File No: SF15/29490
Ref No: DOC17/480207

Response to Request for Further Information for United Wambo Open Cut Coal Mine Project, (SSD 7142 DA 305-7-2003 MOD 16 and DA 177-8-2004 MOD 3)

Rajeev Maini
Manager, Conservation
Heritage Division
Office of Environment & Heritage
As Delegate of the Heritage Council of NSW
6 October 2017

Figure 6-1: Listed and Potential Heritage Items Within, and in the Vicinity of, the Project Area

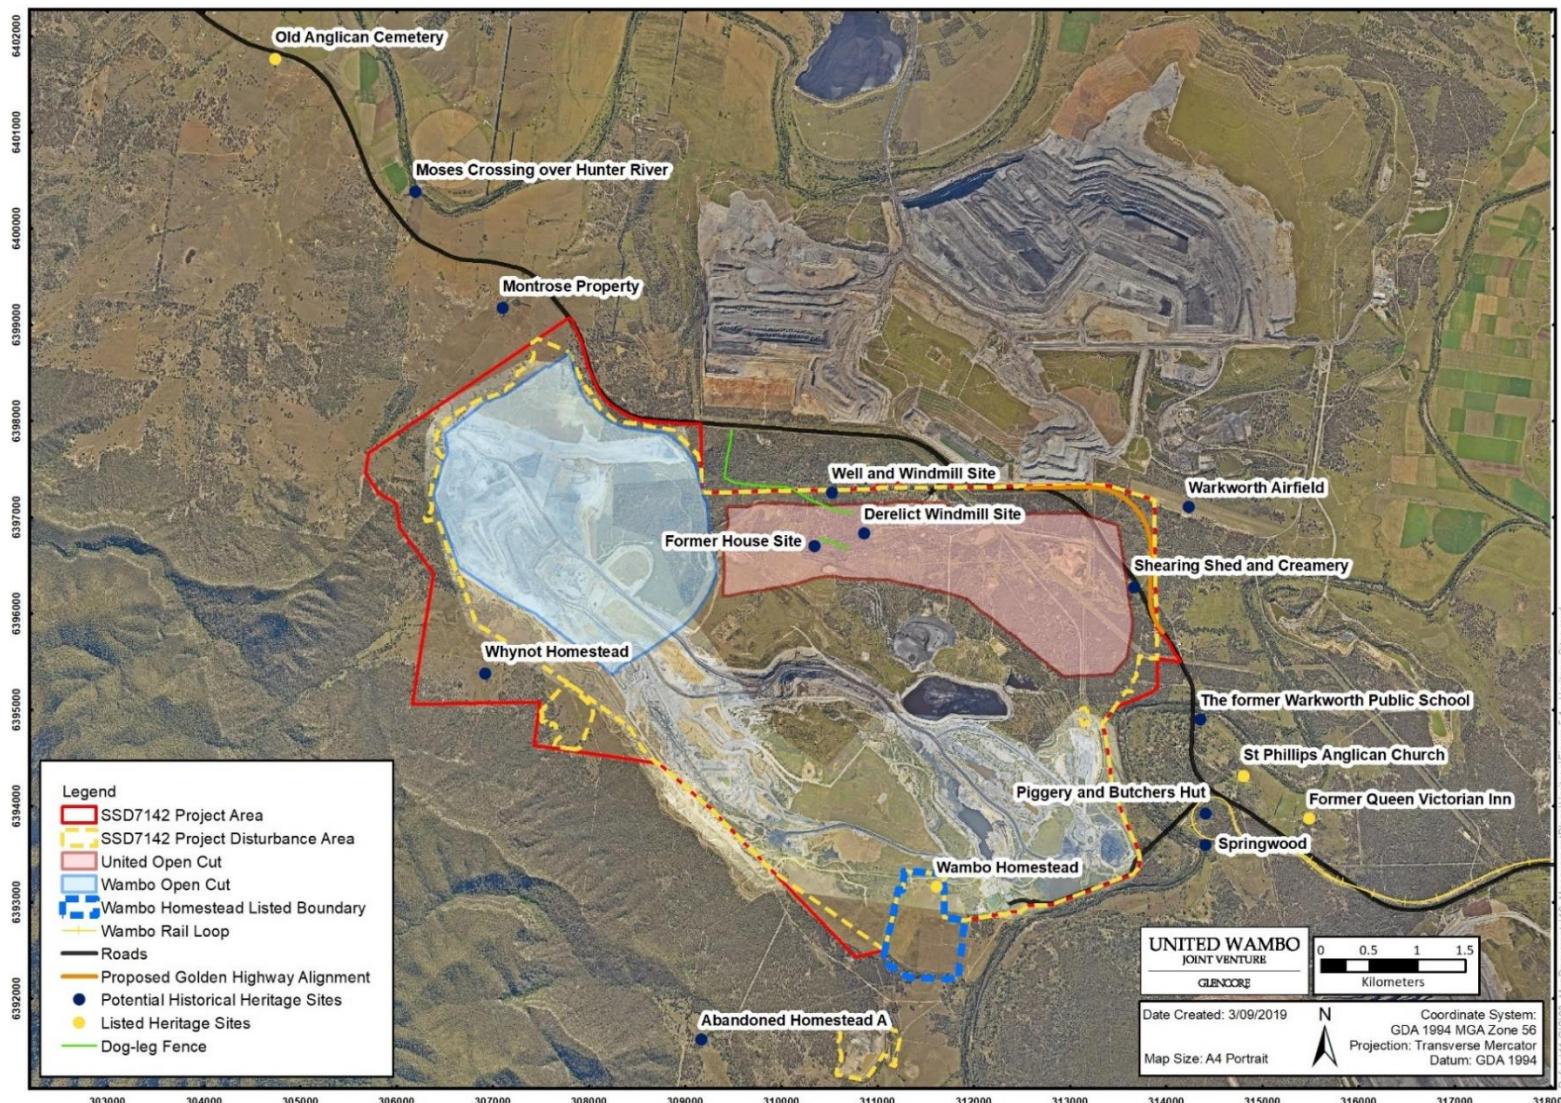
Approximately 17 km of Dog-Leg Fence considered to be of State heritage significance of which 450 m will be removed. To mitigate this impact detailed archival recording and an interpretation strategy is proposed. Prior correspondence from the Heritage Council requested that an updated Statement of Significance for the Dog-Leg Fence be prepared as part of the Response to Submissions Report (RtS). The update was to clearly indicate the significance of the site and provide appropriate management measures based on significance.

This is considered acceptable, but must be specified in an appropriate Condition of Approval if the project is approved by the Department. CoA should require Archival Recording within two years and development and implementation of Interpretation for the Dog-Leg Fence.

This site was assessed in the EIS to be of local heritage significance with the potential to reveal archaeological information about the local area and would be removed by mining. To mitigate this impact archaeological excavation of the site is proposed. Prior correspondence from the Heritage Council advised that the mitigation measures provided did not include sufficient detail such as an archaeological research design or method as to the size and scope of the proposed archaeological excavation. This information should be completed and forwarded to the Heritage Council for approval prior to works progressing on site

This is considered acceptable, but must be specified in an appropriate Condition of Approval if the project is approved by the Department. CoA should require preparation of an Archaeological Research Design and Methodology to be approved by the Heritage Council of NSW or its Delegate prior to the undertaking of archaeological work at the Former House site. This has been included in a draft condition below.

The prior Heritage Council comment has not been addressed. If the project is approved by the Department a CoA should require preparation of a full archival recording in accordance with Heritage Council guidelines. That record should be lodged with DPE, the Heritage Council and the local Council. These requirements have been included in draft conditions below.

The prior correspondence (letter dated 22 September 2016) also queried whether the local sites including the Shearing Shed and Creamery, may contain archaeological relics. The Umwelt report advises that United will commit to undertaking further investigations of the potential for relics as a mitigation measure prior to any disturbance of the site, to ensure any relevant heritage values are recorded. This has been included in draft Conditions below.

This property is located to the northwest of the Project Area approximately 750 metres from proposed extension to the northwest corner of the approved Wambo Open Cut. The Montrose Property has no statutory listing but was assessed as having local significance. Ongoing management of the Montrose Property is a requirement of the existing Wambo Open Cut project, and the prior letter recommended that a condition report prior to blasting should occur for this site.

The Umwelt report advises that United commits to undertaking a structural assessment of the property prior to any blasting associated with the Project. This should be required through a Condition of Approval and has been included in a draft condition below.
